4 December 2018

Our Ref: R/2014/39/J  
File No: 2018/600170  
Your Ref: SSD 7484 MOD 3

**Modification Application – The Sandstone Precinct – SSD 7484 (MOD 3), 23-33 & 33-35 Bridge Street, Sydney**

SP-DA-G-2500

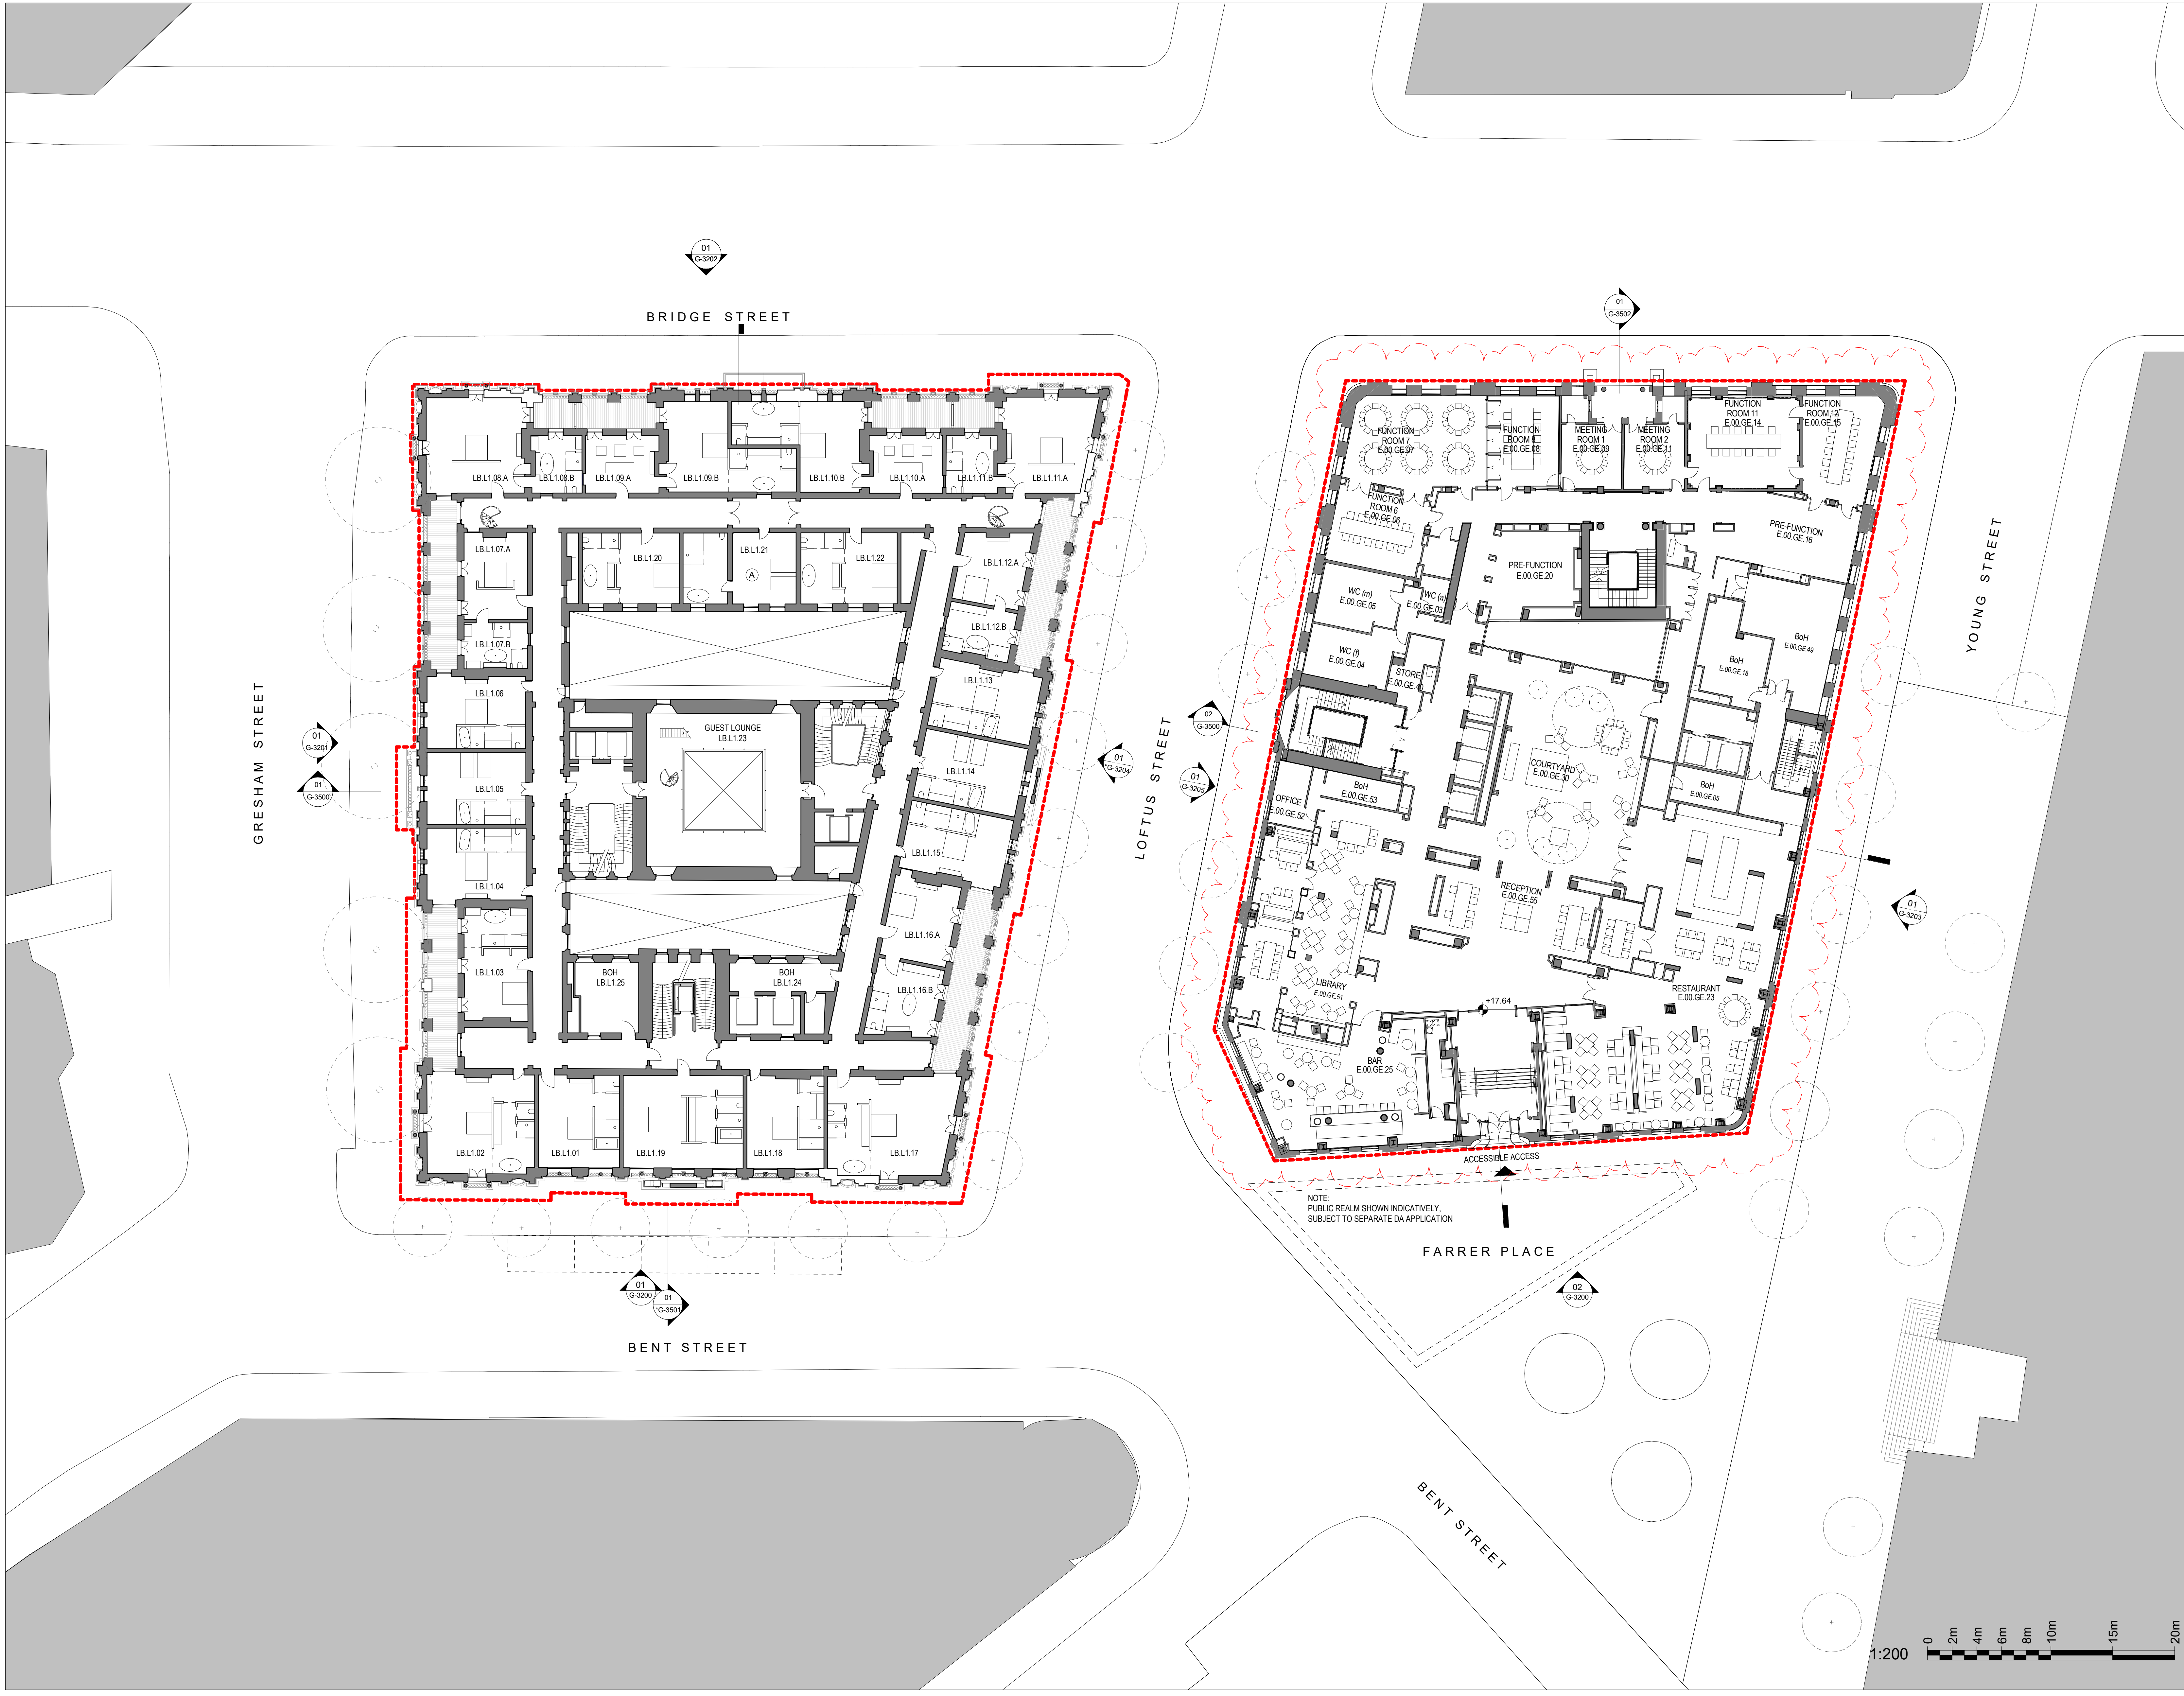
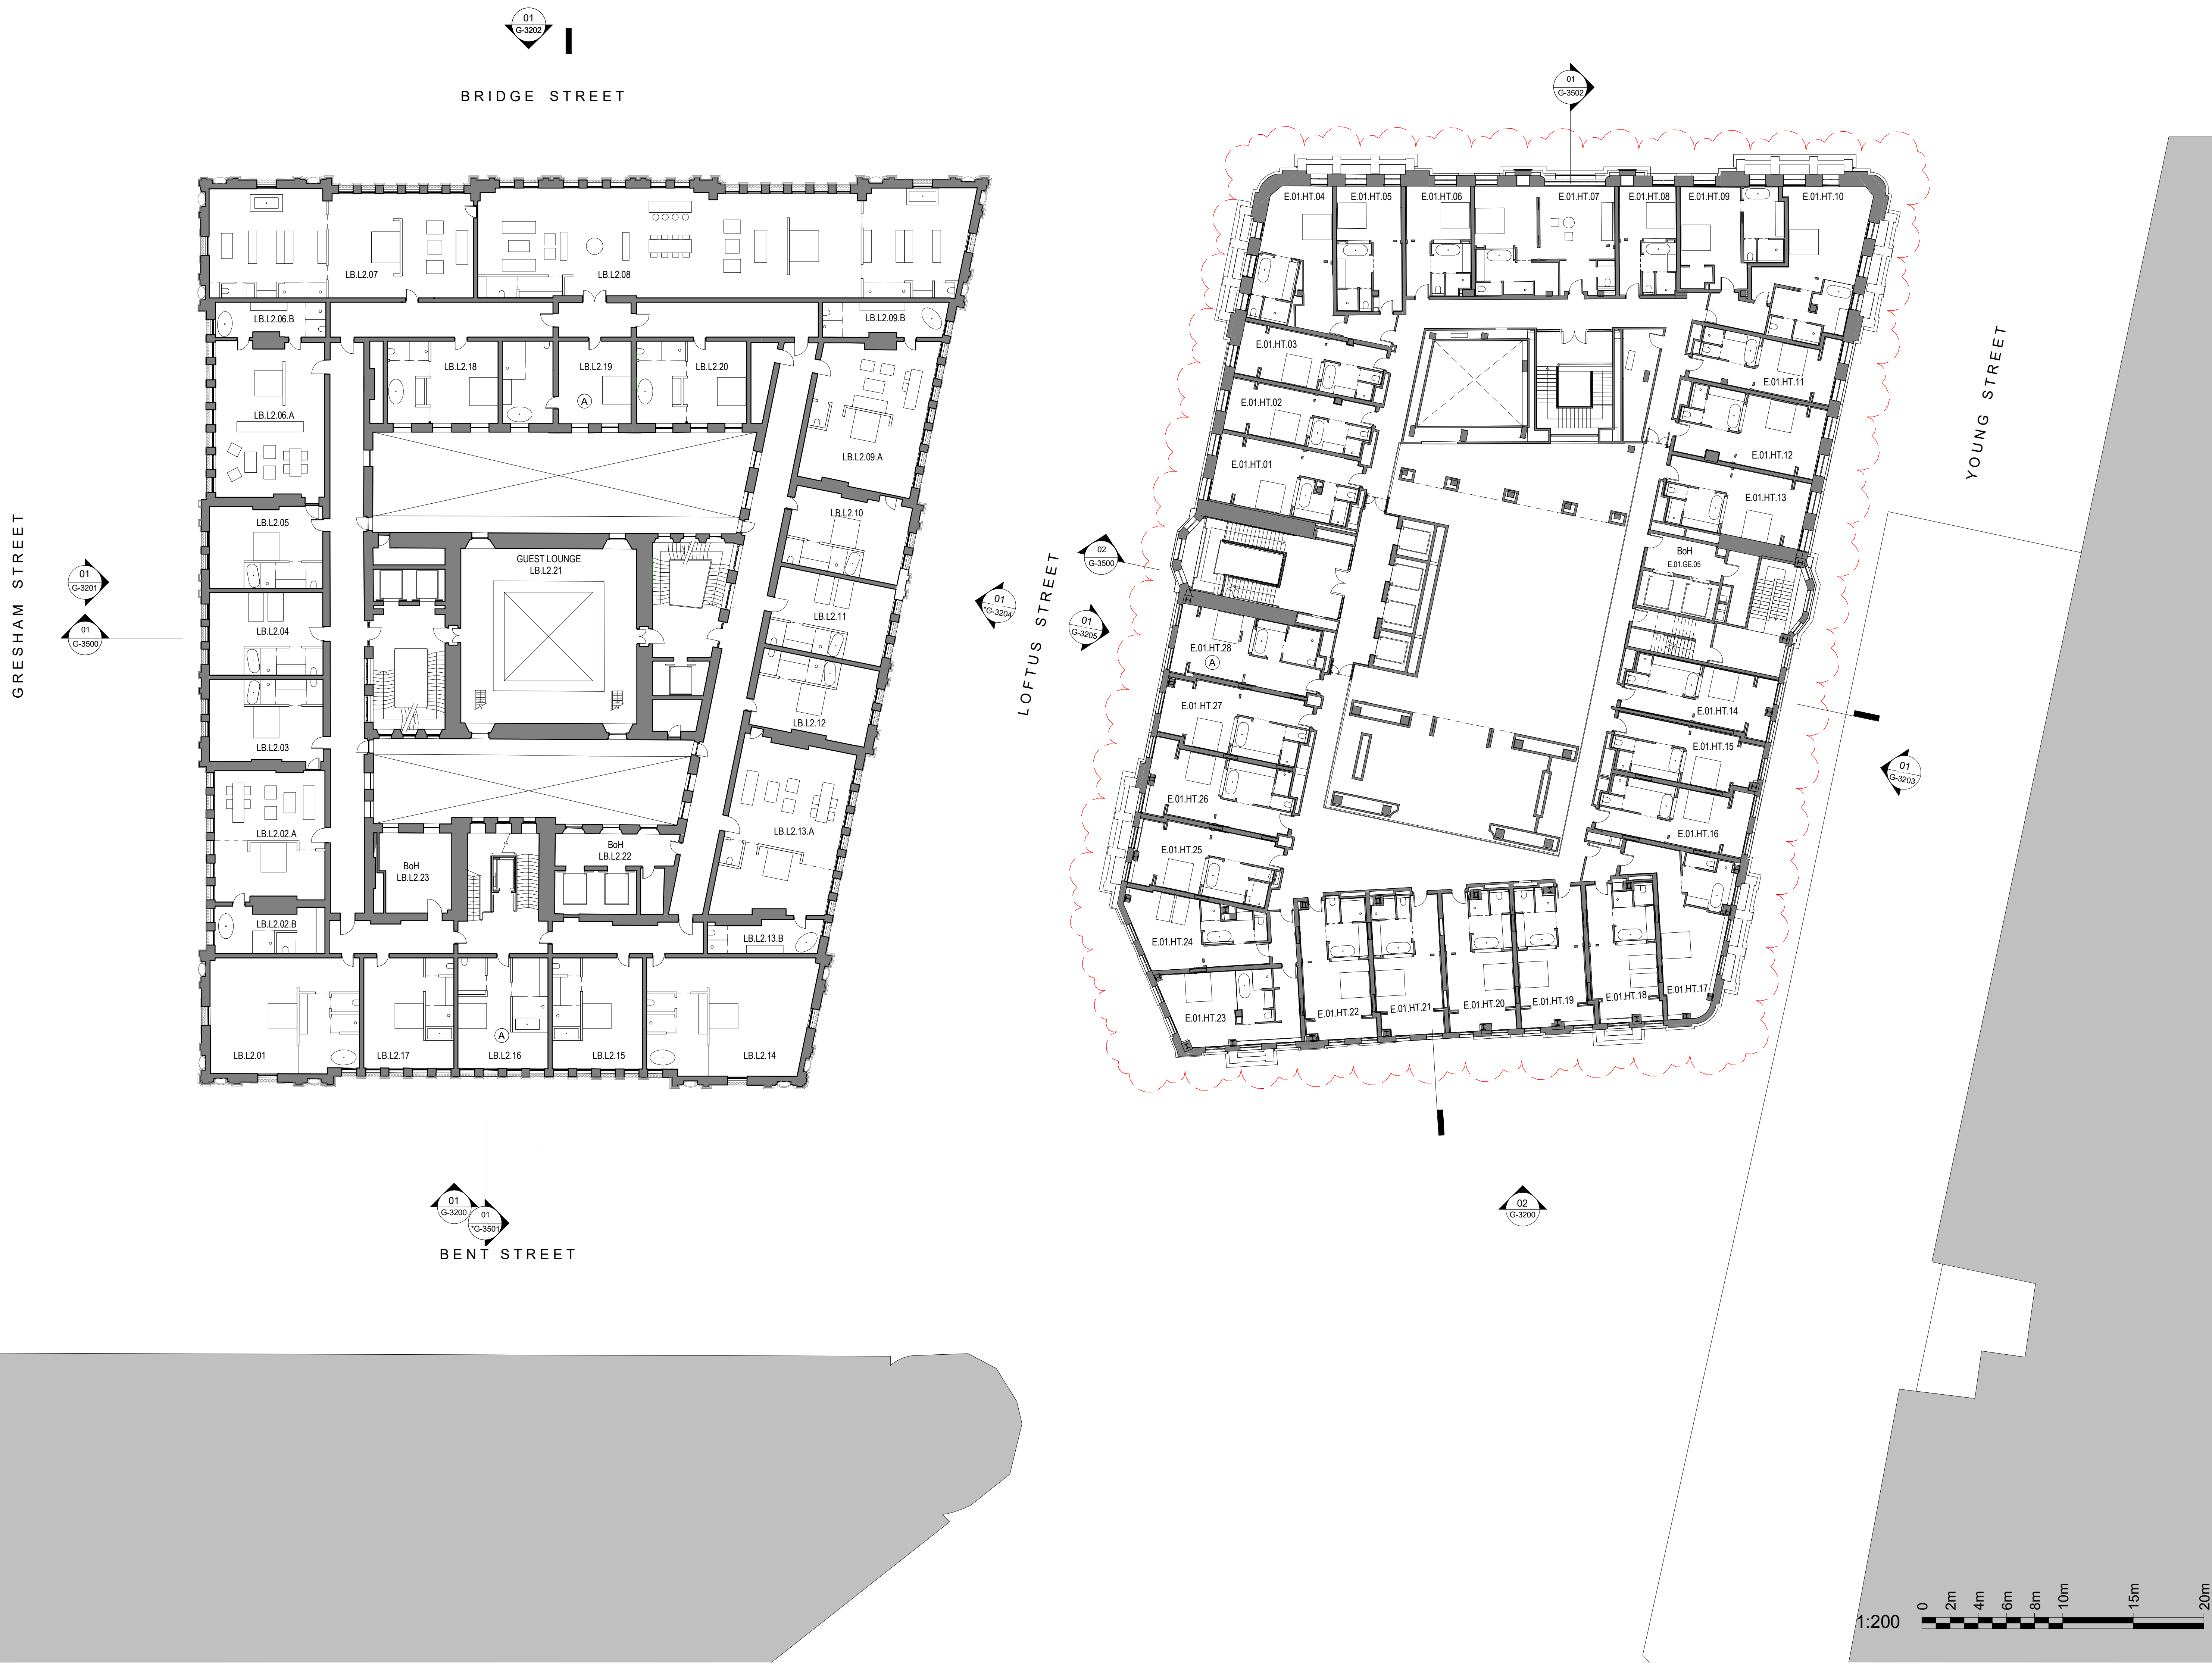
The demolition of the existing wall between ground level function rooms 8 and 9 shown on proposed plan SP-DA-G-2500 is **not supported**. These rooms are of exceptional significance and the proposed demolition will destroy original fabric and disrupt the proportion of the rooms. The proposed operable wall or multiple modern doors (plans are ambiguous) are not acceptable. The single door between these rooms in the approved design provides sufficient connection between the rooms, particularly given that function room 9 is designated as a private function room. This proposed modification is, therefore, **not supported**. [Note that the Heritage Impact Statement appears to have an error. It does not mention the demolition of the wall between function rooms 8 and 9 shown on the plans, and discussed above, but mentions deletion of an opening between Function Room 8 and 10 which is not shown on the plans].
